Re: Planning Application: AW/353/14PL
11 Marquis Way, Bognor Regis, PO21 4AT

I am writing on behalf of my wife and I, as long standing residents of Marquis Way, to object to the proposed demolition and rebuild of 11 Marquis Way, Bognor Regis, West Sussex, PO21 4AT.

project: 11 Marquis Way - Aldwick			
drawing title: Proposed Site Plan			
drawing status: Planning Application			
date: 09 - 12 - 2014	scale at relevant drawing size 1 : 50 (A1) or 1 : 100 (A3)	no: JW131105 - PL10	rev.: -

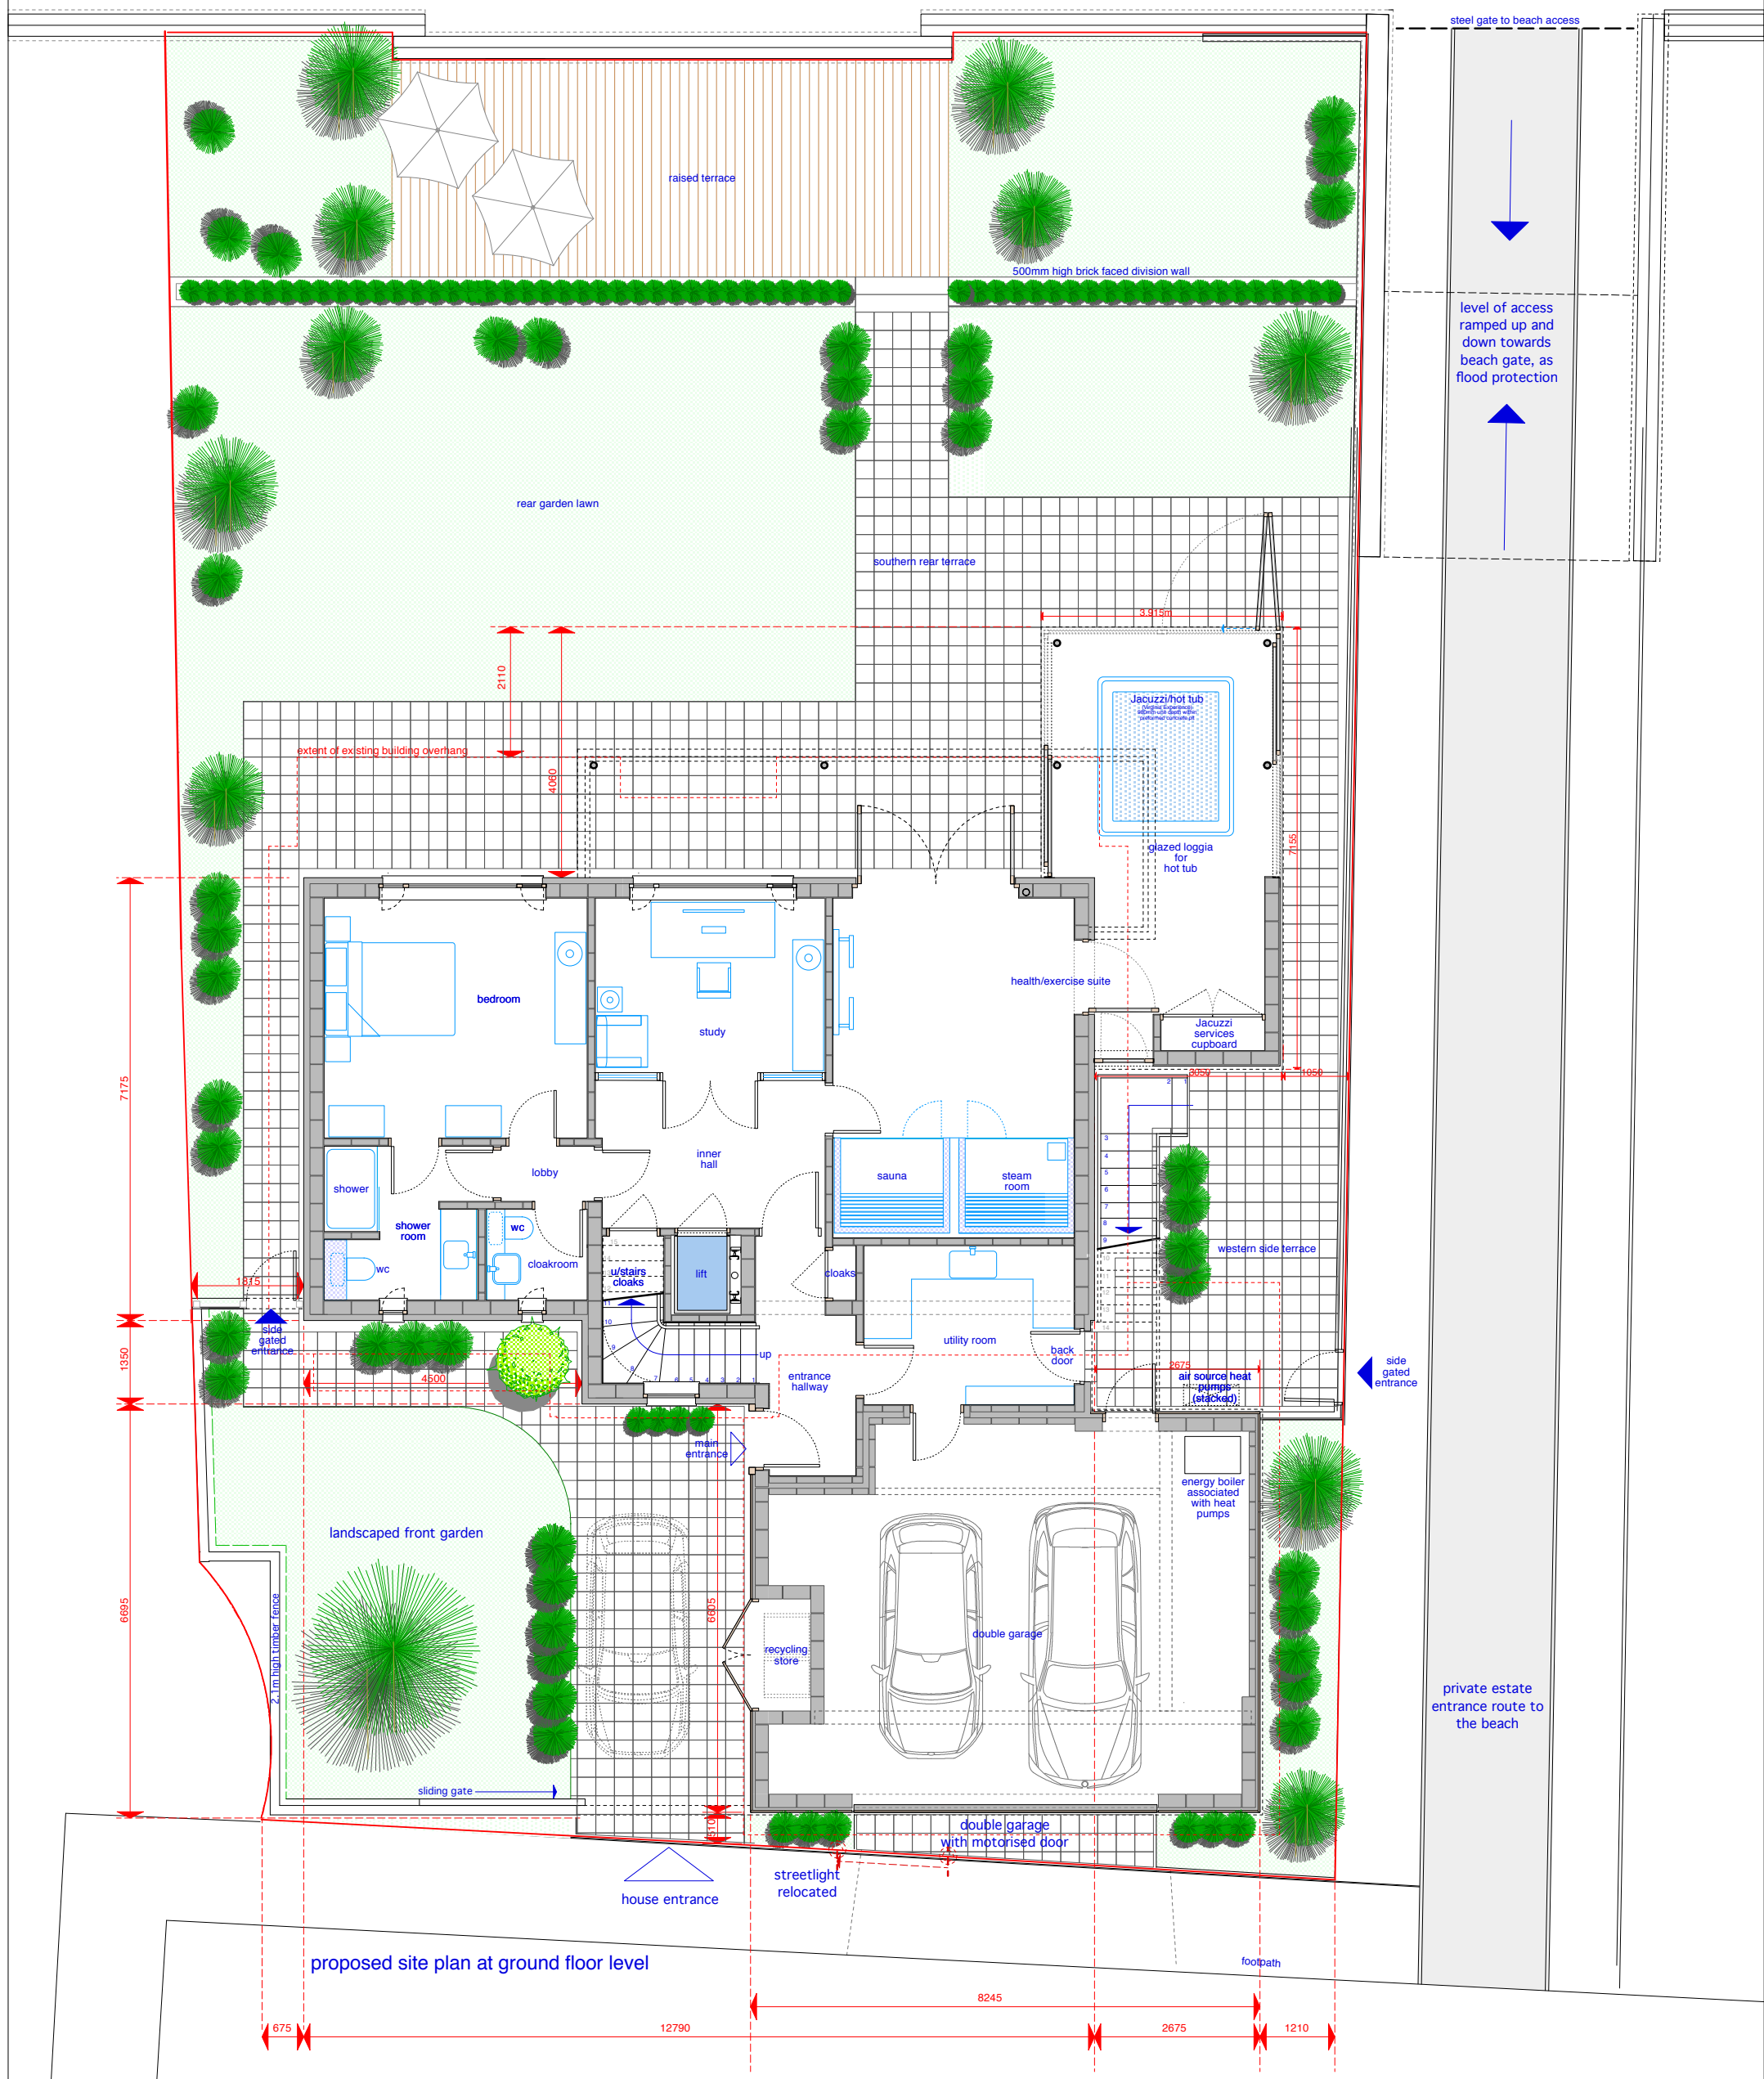
The proposed property on the south elevation breaches the building line, which was enforced when planning approval was granted on our extension (No 15).

The proposed planning shows the access to the garages entering and exiting straight onto the road, which is a T-Junction and could cause serious problems for people wishing to visit No 9, 10, 12, 14 and 15 Marquis Way, as well as a danger to residents who use the road daily.

project:	11 Marquis Way - Aldwick		
drawing title:	Proposed Sections A and B		
drawing status:	Planning Application		
date:	scale at relevant drawing size	no:	rev:
09 - 12 - 2014	1 : 50 (A1) or 1 : 100 (A3)	JW131105 - PL19	-

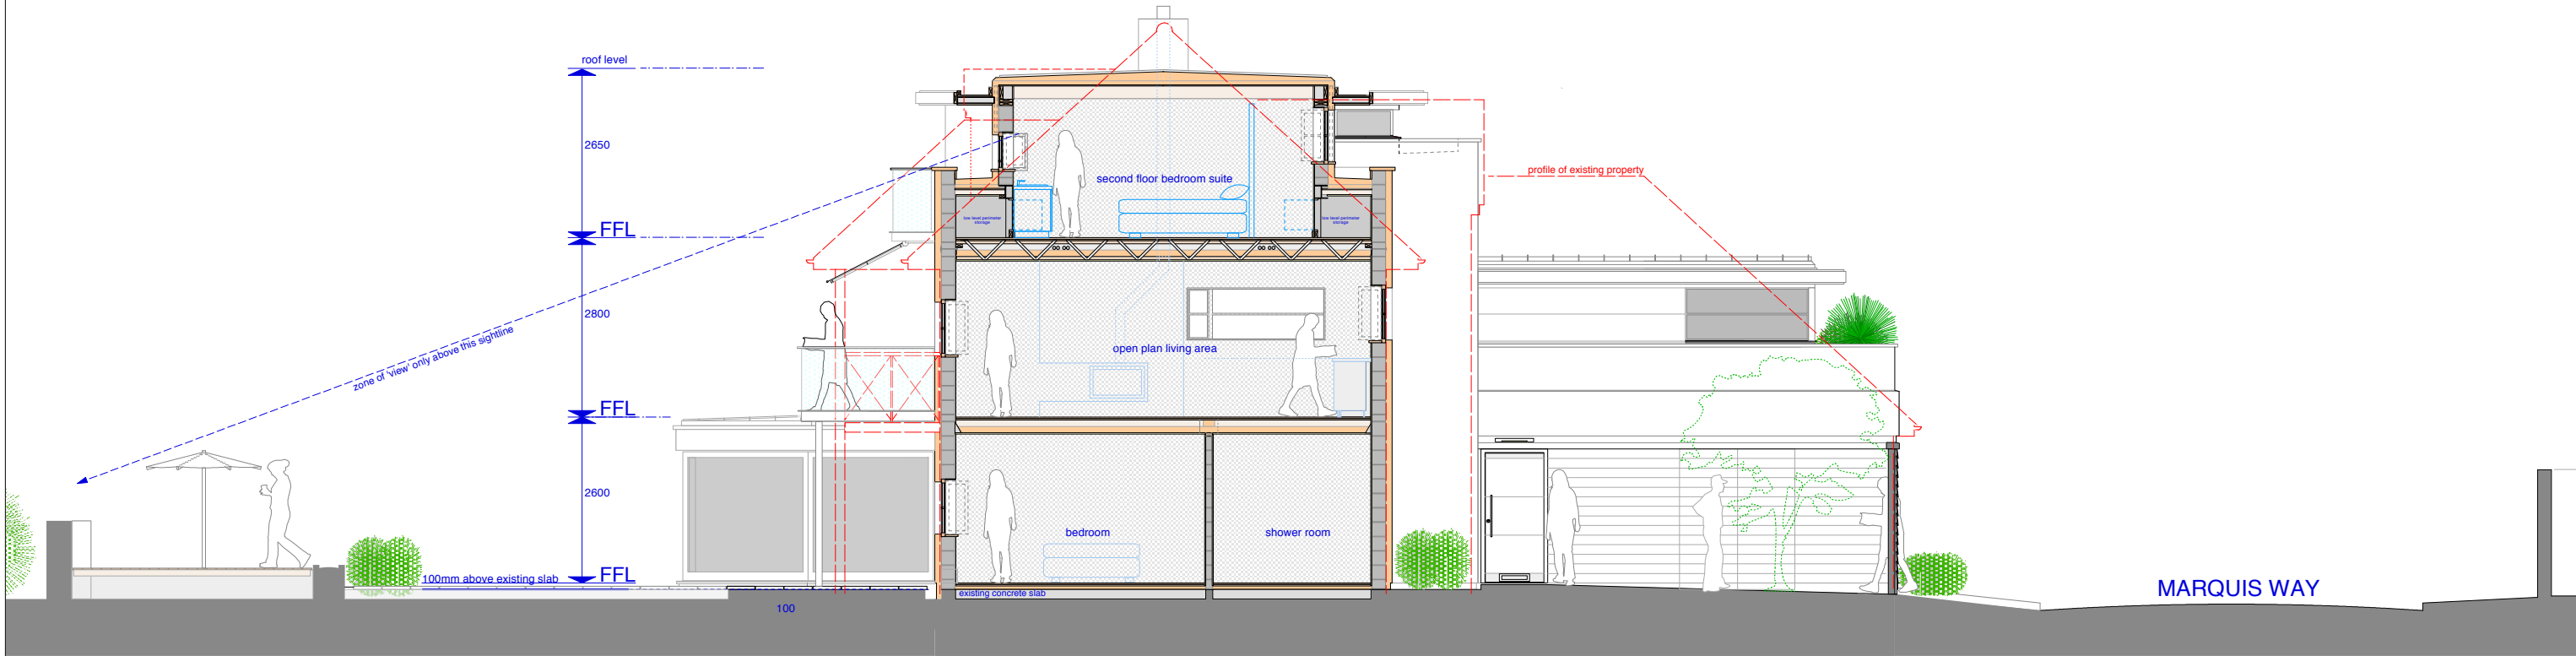
A concerning element is the extensive first floor balconies which differ significantly.

A number of properties not currently overlooked will have the intrusion of the first and second floor, north and west facing balcony, with direct sight into their properties.
